TR020002: Manston Airport

Application review

This document consolidates the Planning Inspectorate's observations and advice to RiverOak Strategic Partners (RSP) in respect of the content of the following application documents submitted on 10 April 2018:

KEY

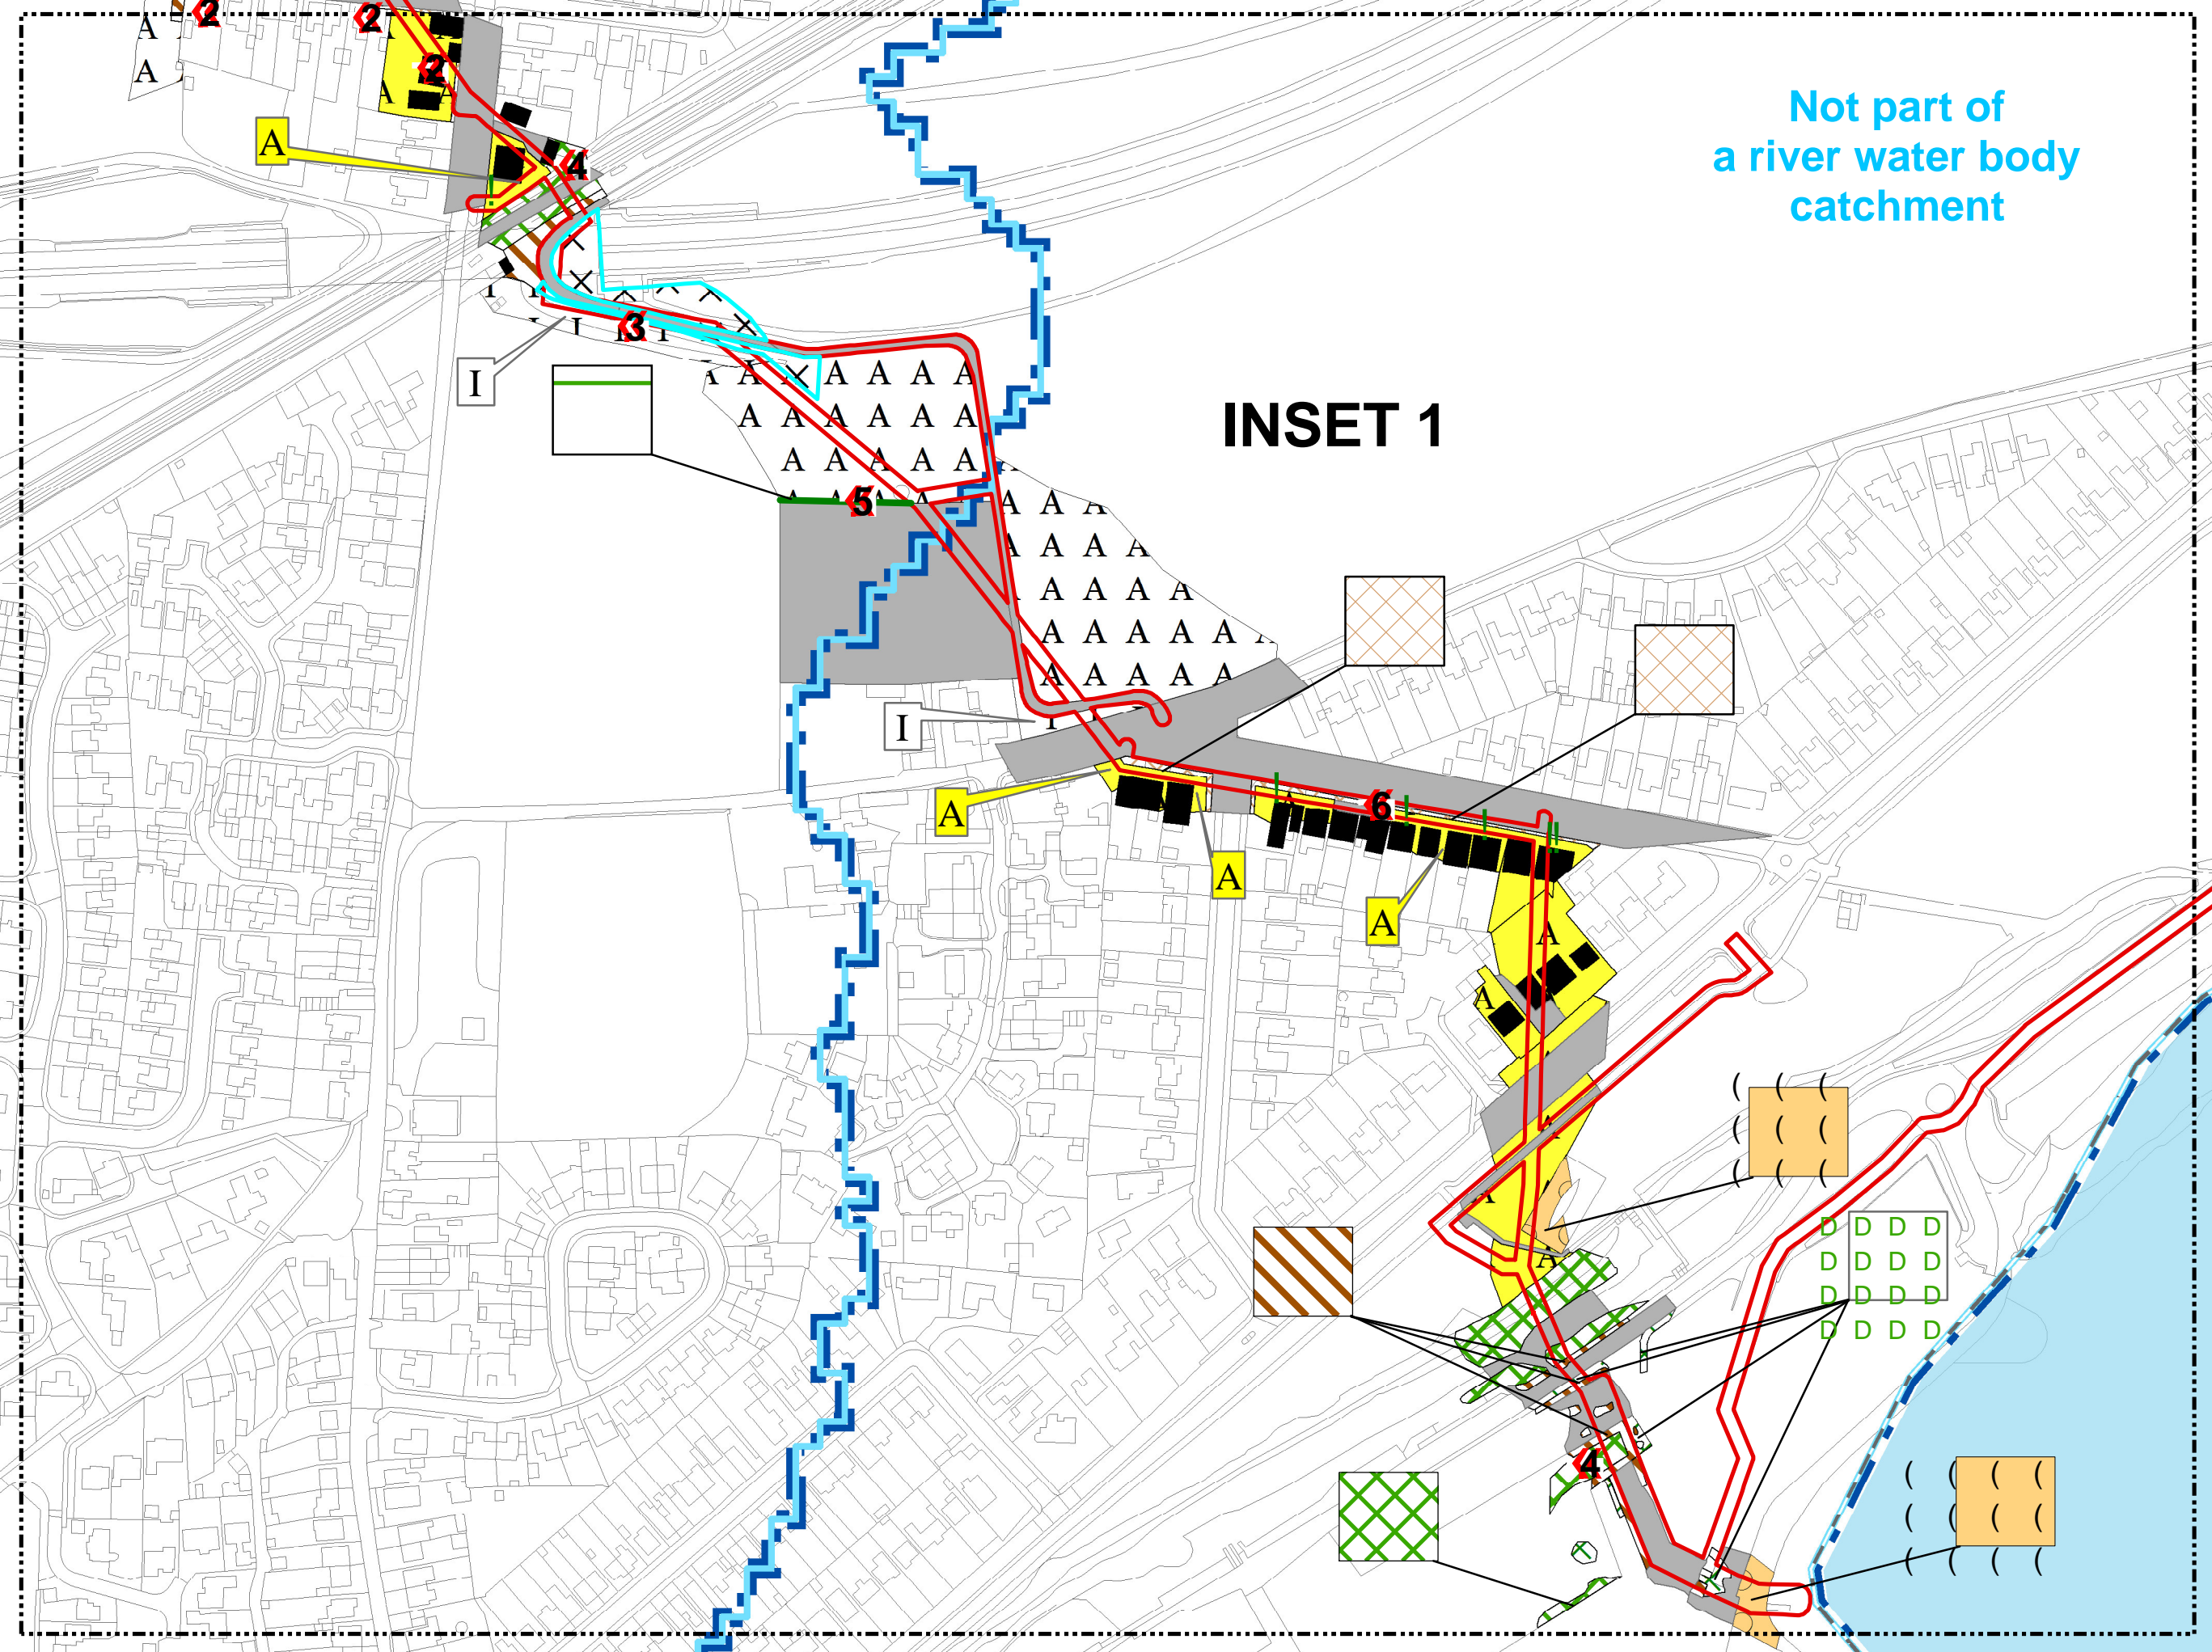
Revision number(s) were not stated on the Habitats of Protected Species Plans.
